Application No: M/91/25/HH

Site Address: 15 Old Point Middleton-On-Sea PO22 7RY

Description of works: Two storey front, rear and side extensions. Loft extension. Internal alterations.

Thank you for your internet representation made on 10th December 2025 which has been recorded as an objection with the comments as follows:

PROPOSED SECOND FLOOR PLAN
 Sc. 1:100

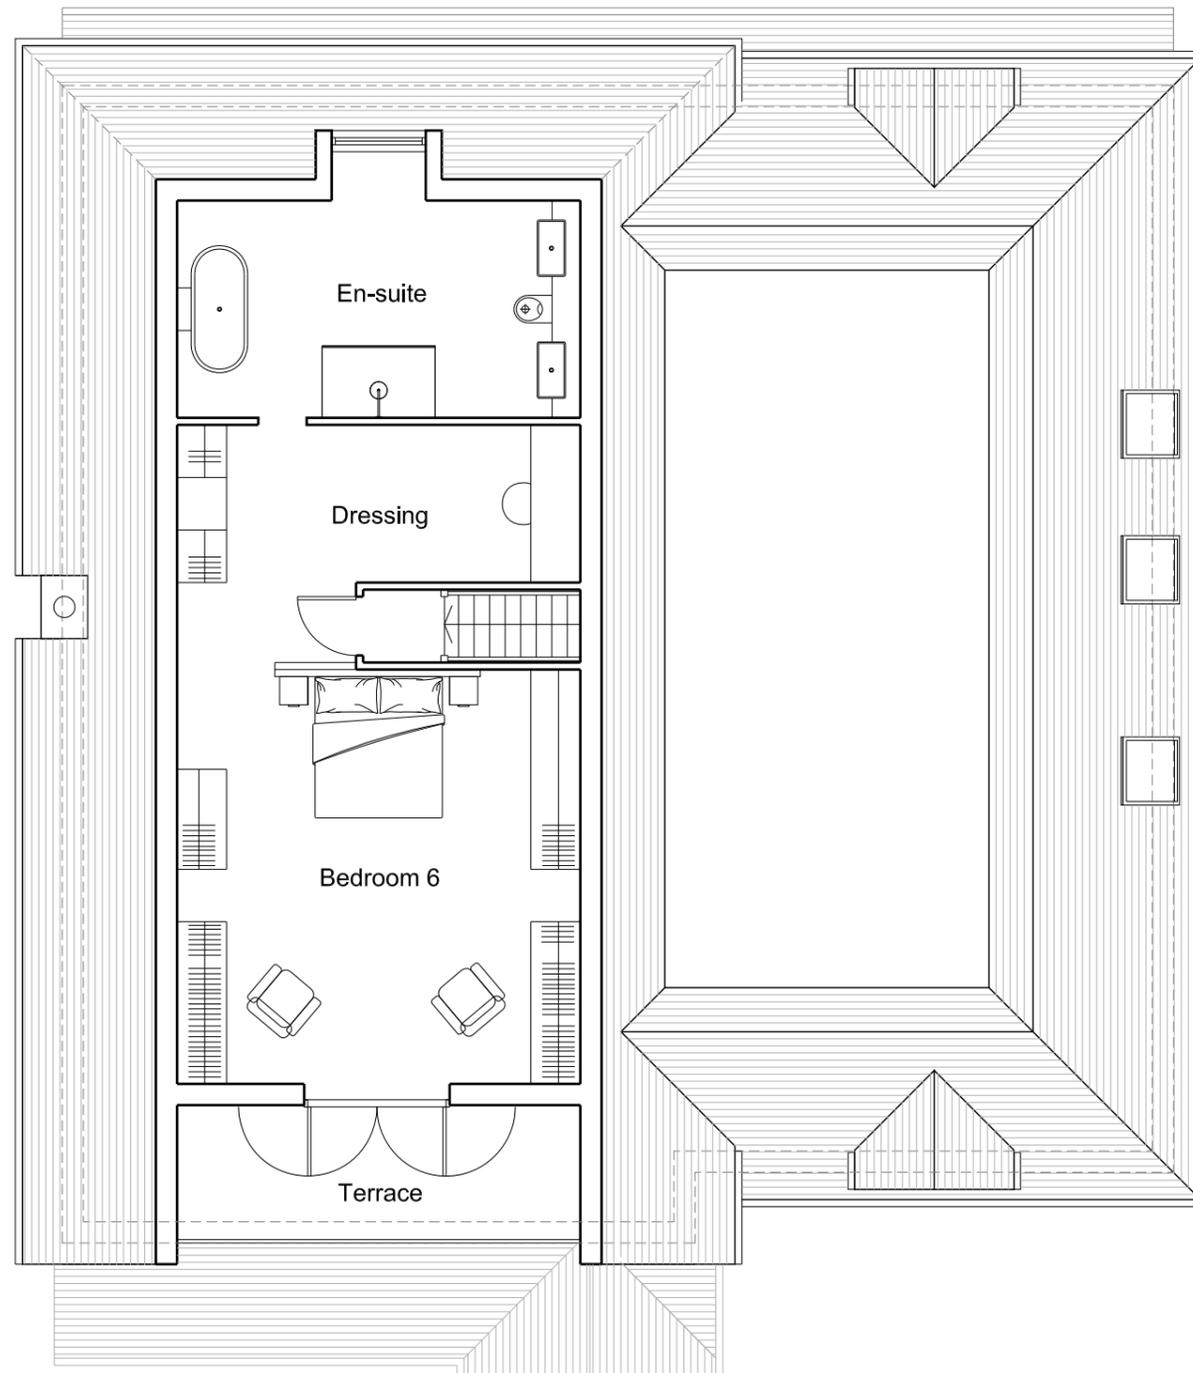
I object to the second floor balcony which will overlook our property
